CITY OF PORTLAND, MAINE

May 25, 2016

Project Name: AC Hotel
Address: 158 Fore Street
Applicant: Portland Norwich Group

Project ID: 2015-169
CBL: 19-B-2
Planner: Nell Donaldson

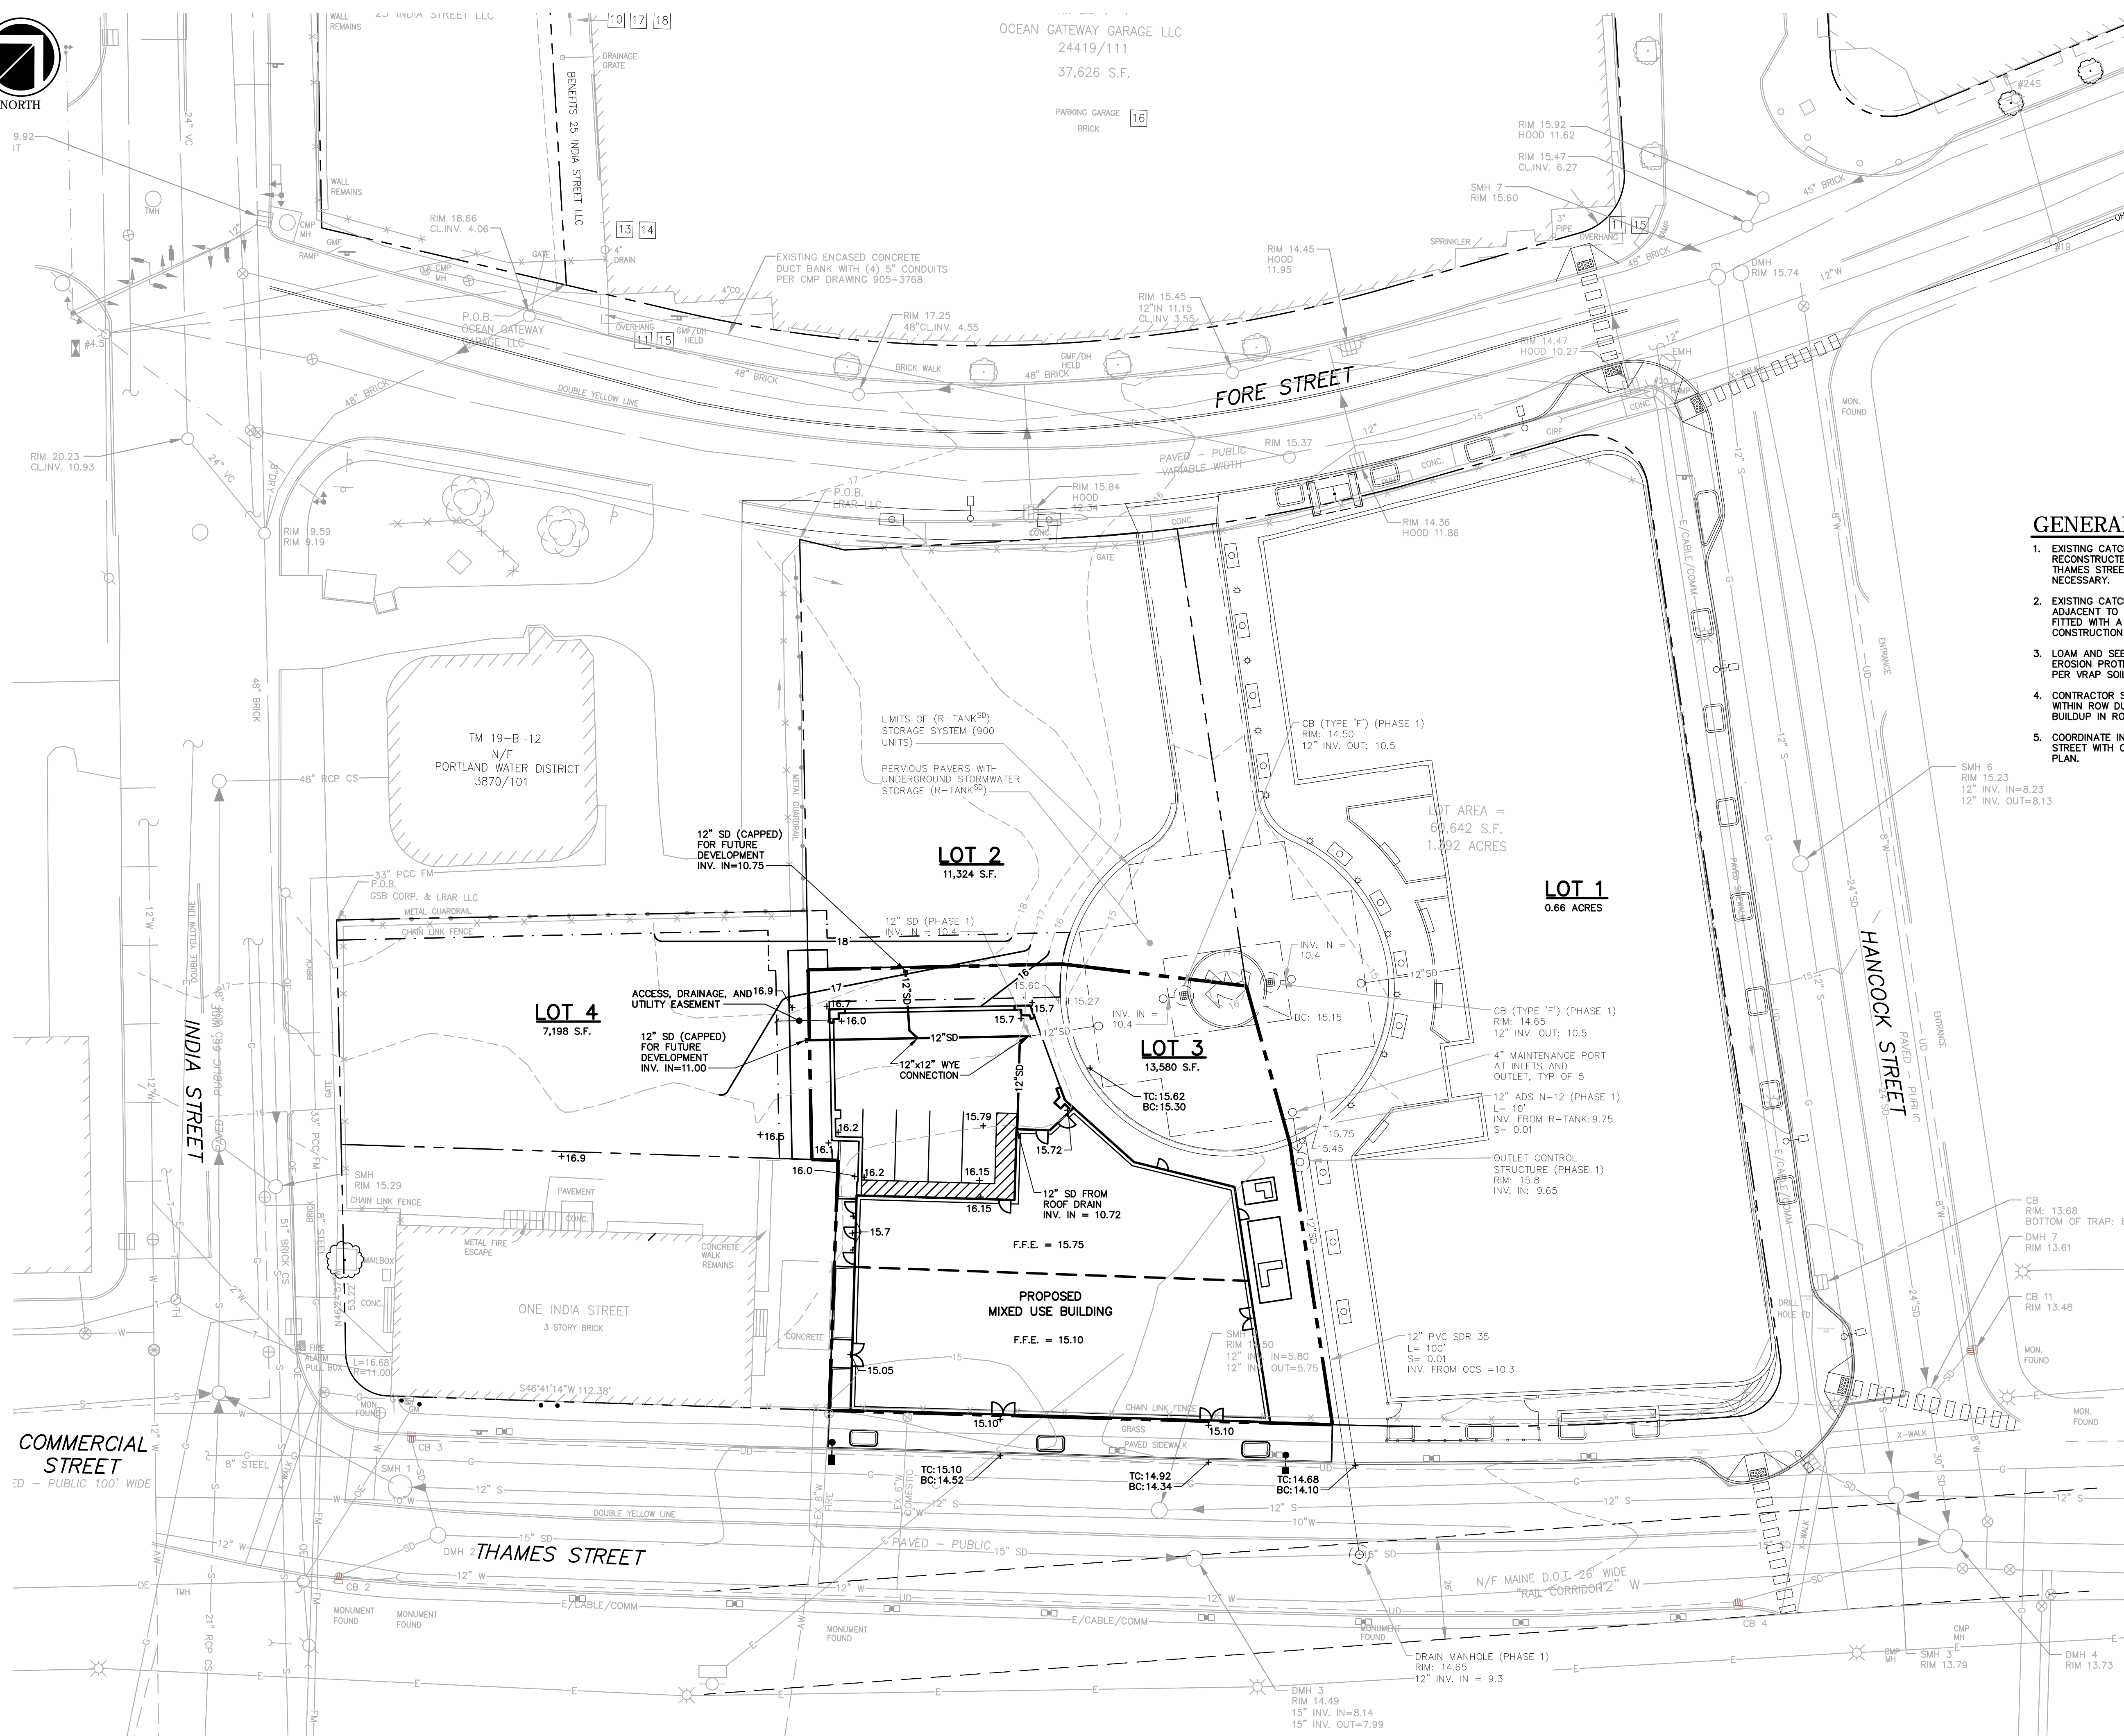
8. The applicant shall revise plans to depict ADA-compliant perpendicular crosswalks and provide sign and ramp details at Fore and Hancock Streets and Fore and Thames Streets for review and approval by the Department of Public Works;

The applicant's plans do include a number of modifications to the surrounding street network, including the addition of on-street parking on the south side of Fore Street, with curb extensions at the intersection of Fore Street and Hancock Street. These curb extensions mirror existing bumpouts on the southern end of the site's Hancock Street frontage. These proposed changes in geometry will affect the location of the Fore Street centerline, although these changes have not been formalized in the plans. Mr. Errico notes,

A condition of approval shall be included that notes the applicant is required to prepare, for review and approval to the satisfaction of DPW, a pavement marking plan. The applicant shall be responsible for implementation of the plan. All details and specifications for implementation shall be approved by the City including but not limited to paint specifications and existing paint removal methods.
